Application: SSI 7485

I write regarding the proposed modification to M4-M5 Link, Mod 2 The Crescent overpass and changes to pedestrian infrastructure in North Annandale, Rozelle and Rozelle Bay Foreshore area.

Figure 4-2 Pedestrian and cyclist bridge infrastructure options

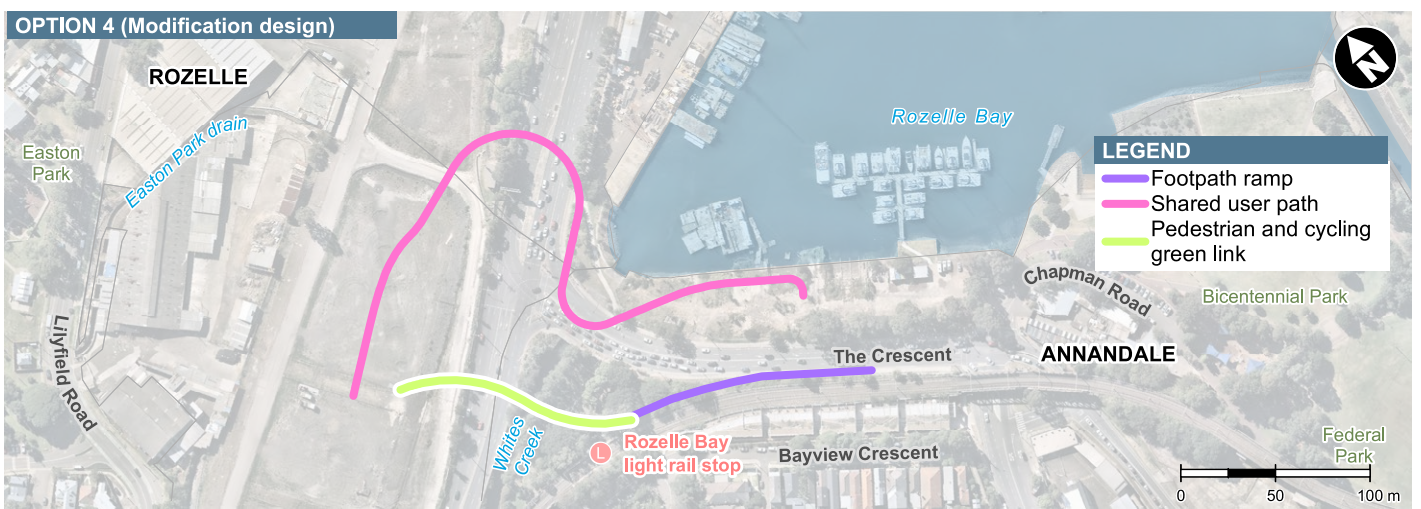
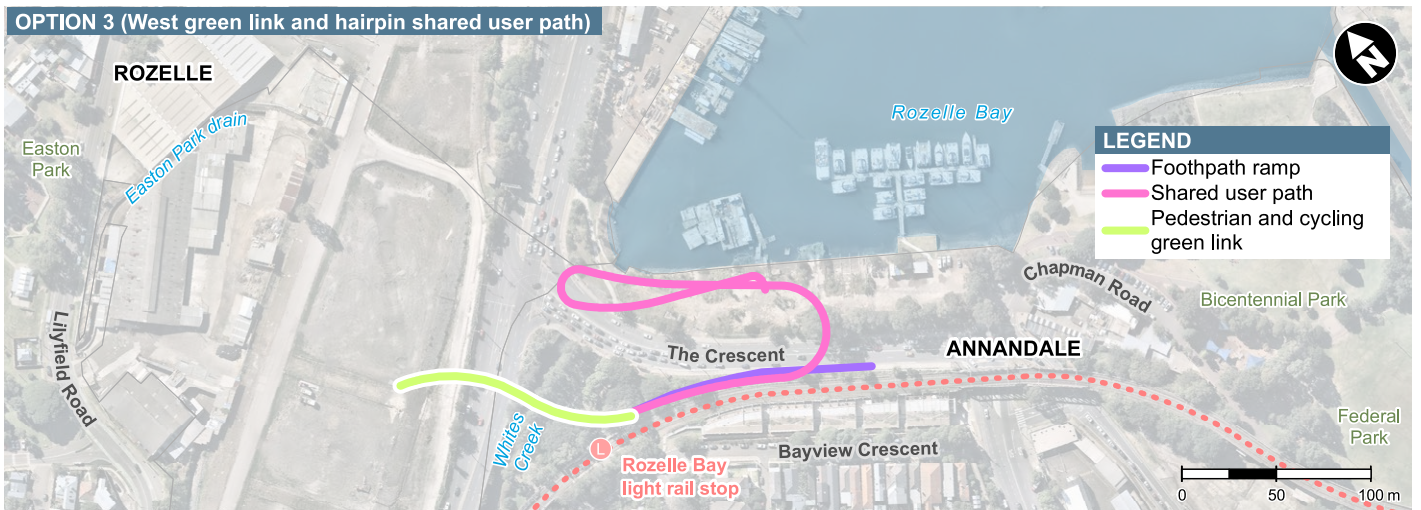
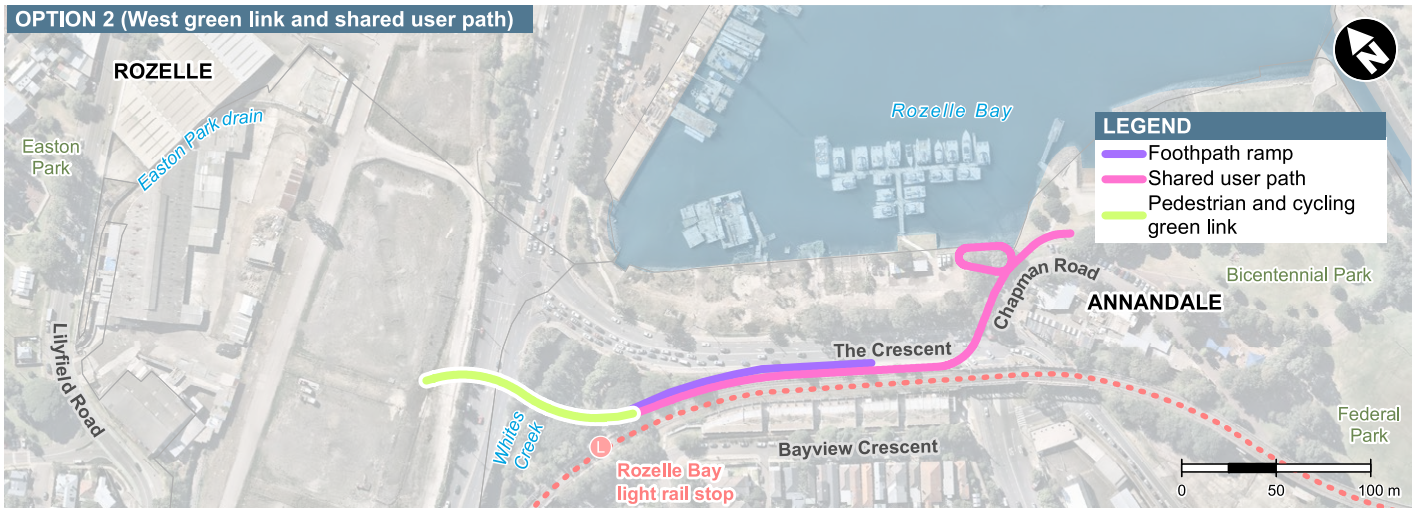
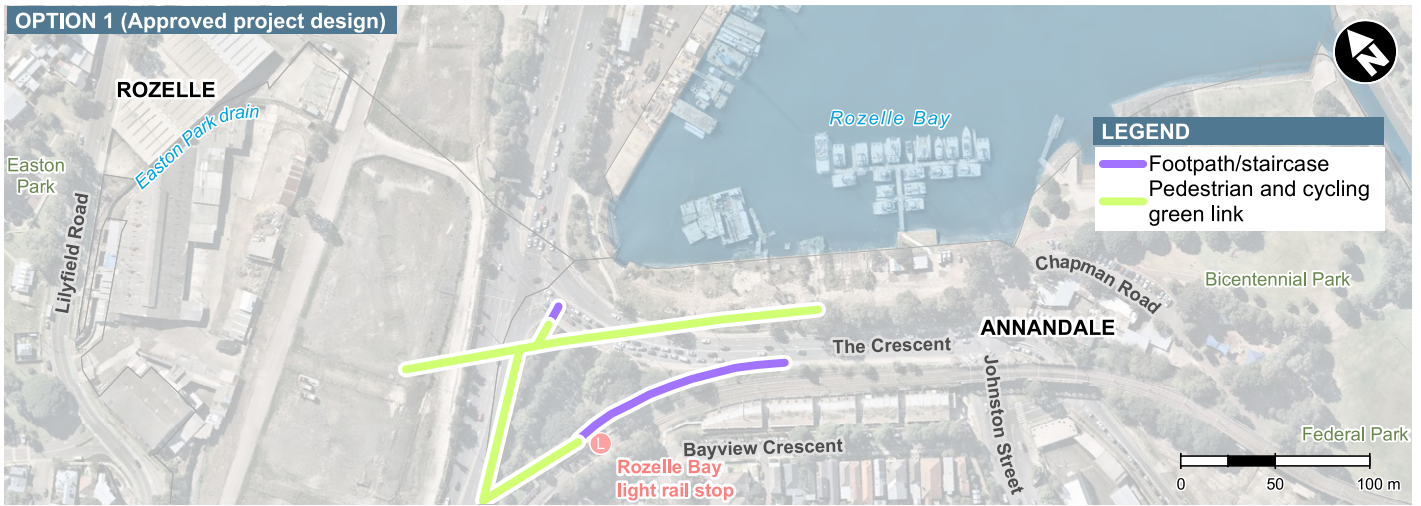
The overpass has significant visual and urban impacts. It has forced the relocation of the green bridge west of The Crescent requiring a pedestrian crossing of four traffic lights.

It has added another elevated pedestrian crossing from the same starting point in the new Goods yard parklands. This crossing is longer than it needs to be due to extra height required to get over the new vehicle overpass. These changes have greatly added to the visual impact and clutter.

- **Reinstate the GreenLink connecting communities and green open space from Rozelle to Bicentennial Park**
- **Improve pedestrian connectivity.**

Directly connect pedestrians from the new Rozelle parklands with Rozelle bay and the Glebe foreshore.

Figure 4-3 The Crescent, Johnston Street, Chapman Road intersection options

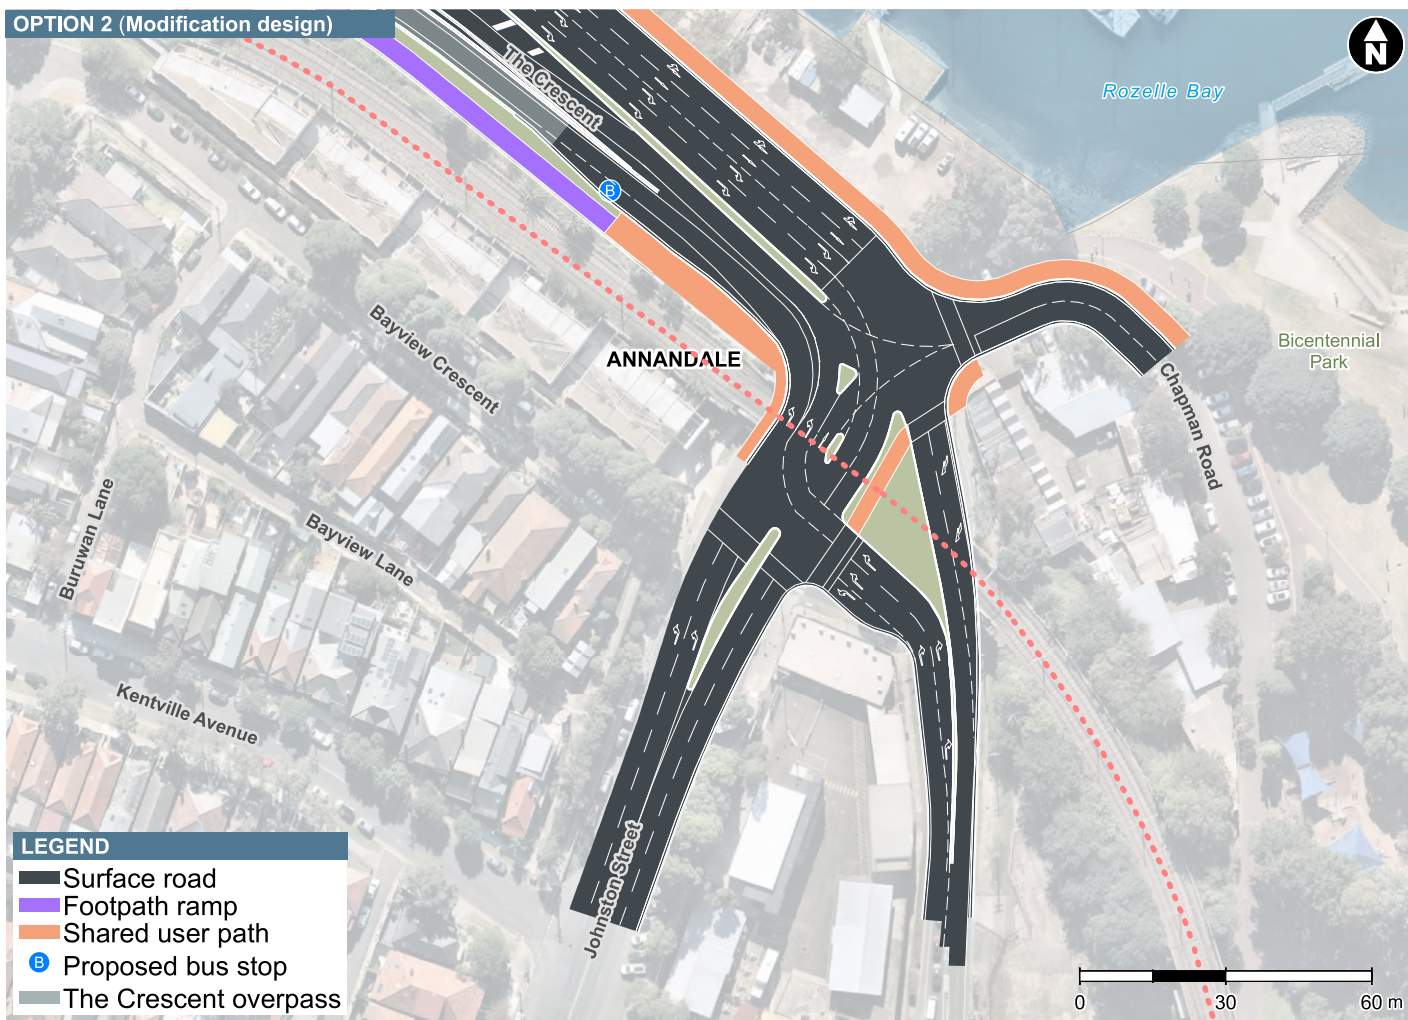
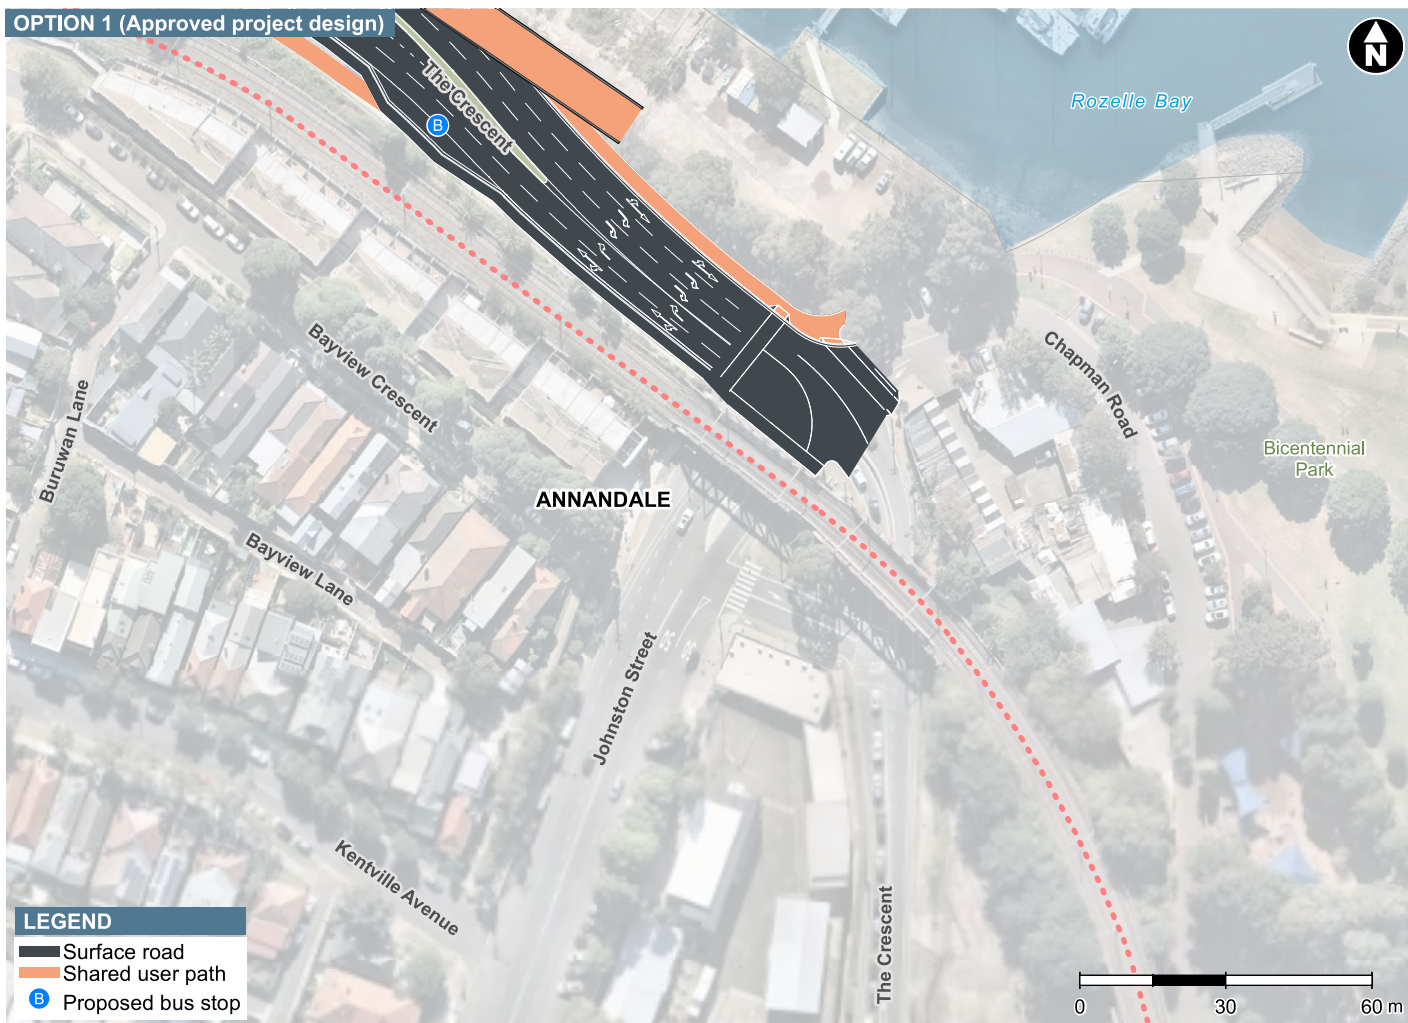
It did not adequately address the far greater urban design outcomes of options 1 and 2 (at grade and overpass options).

The proposal bottlenecks the majority of vehicle movements turning right to Victoria Road and the Anzac bridge from three lanes down to one lane with likely traffic impacts up Johnston street and The Crescent.

It doesn't allow a right hand turn into James Craig road.' From The Crescent heading city bound.

Return the Johnston Street / The Crescent pedestrian crossing to a single traffic light as per the current situation, and location.

- **Local traffic** Reinstate the right hand turn lane at the Crescent from Johnston Street.
- Design the modification infrastructure and active links in response to the character of the suburbs, the location of the foreshore and it's potential future development.
- Provide pedestrian and cyclist paths that maximise people safety and do not force them onto busier streets, unsafe concrete plazas and caged walkways.
- Integrate active and direct connections to all active transport - including the future Metro West and Foreshore Ferry Wharf.

Figure 4-4 Elevation: Indicative view of The Crescent overpass

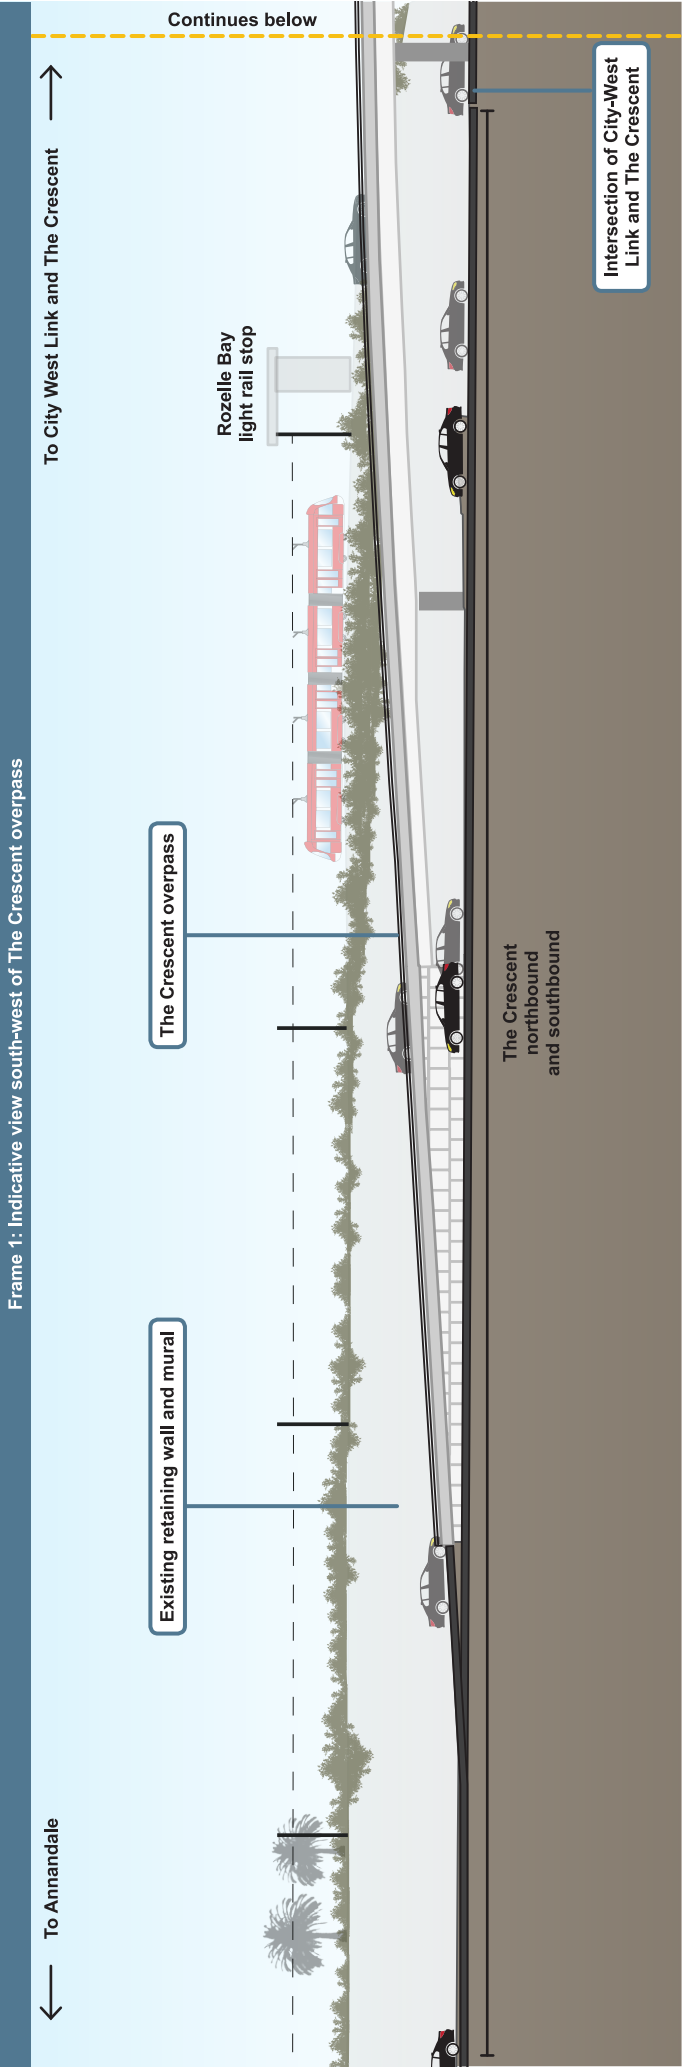
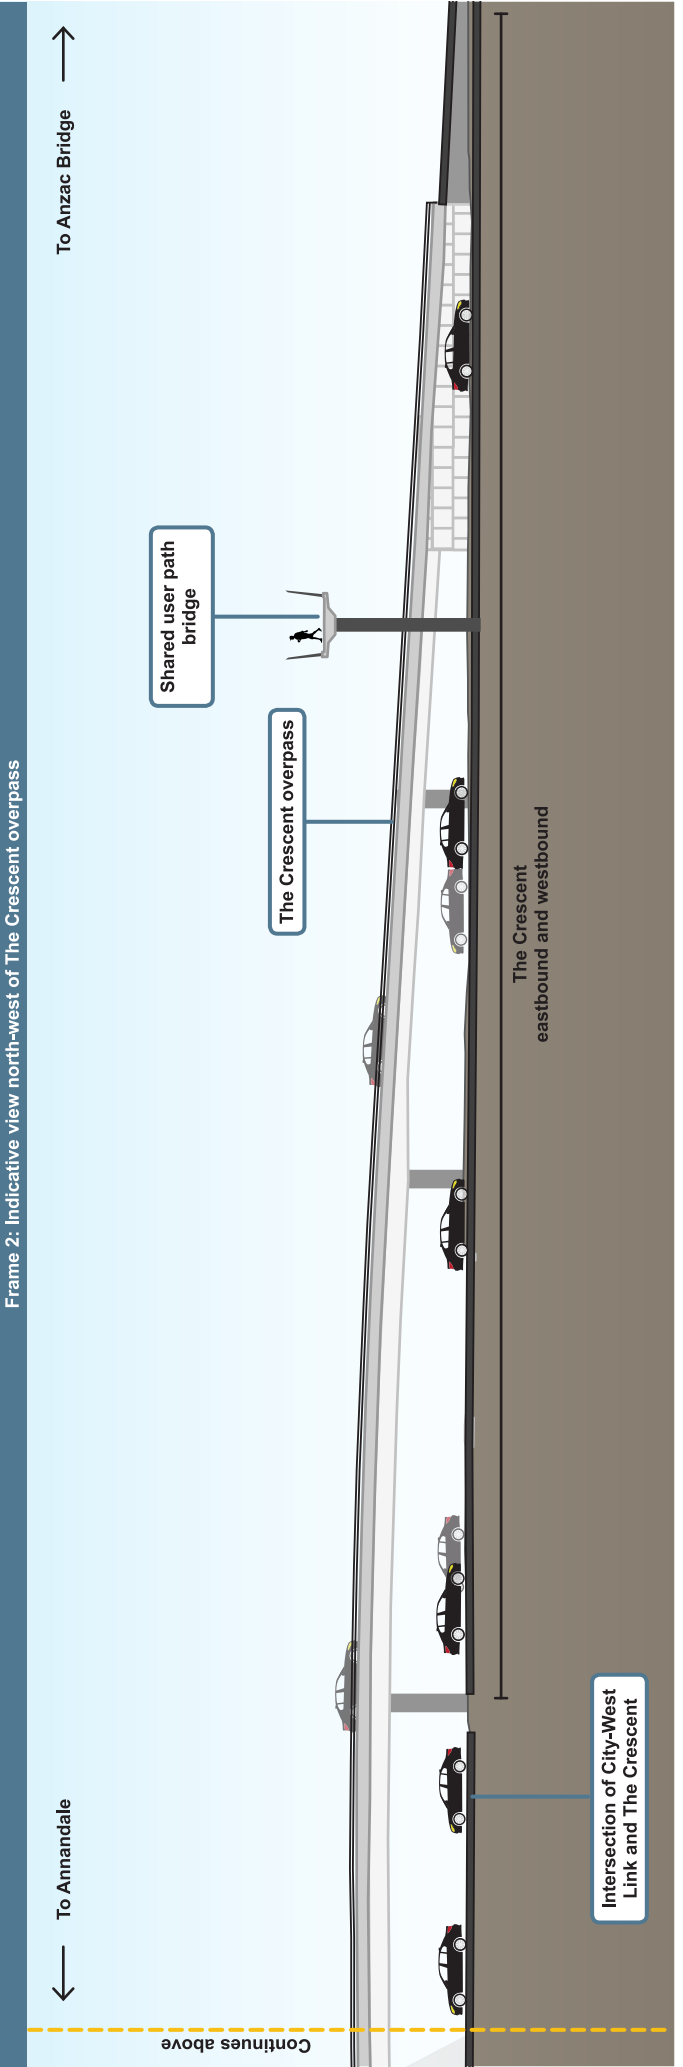
- **Remove the overpass.**

We object to the proposed overpass option. It has limited improvements to

vehicle waiting time, but these are outweighed by significant visual and pedestrian connectivity impacts.

It blocks views of the water from the relocated green bridge.

The overpass should be replaced with an at grade intersection as per the EIS or a short 120m tunnel option with a single land bridge option.

Change the overpass to a short (less than 120m) tunnel under the city West link with slot trench approaches rather than the proposed overpass. This underpass needs to be designed to also facilitate the single pedestrian crossing at Johnston's Street. An underpass provides the best visual and urban outcomes. It allows the retention of the green bridge in a location to best connect the parklands together.
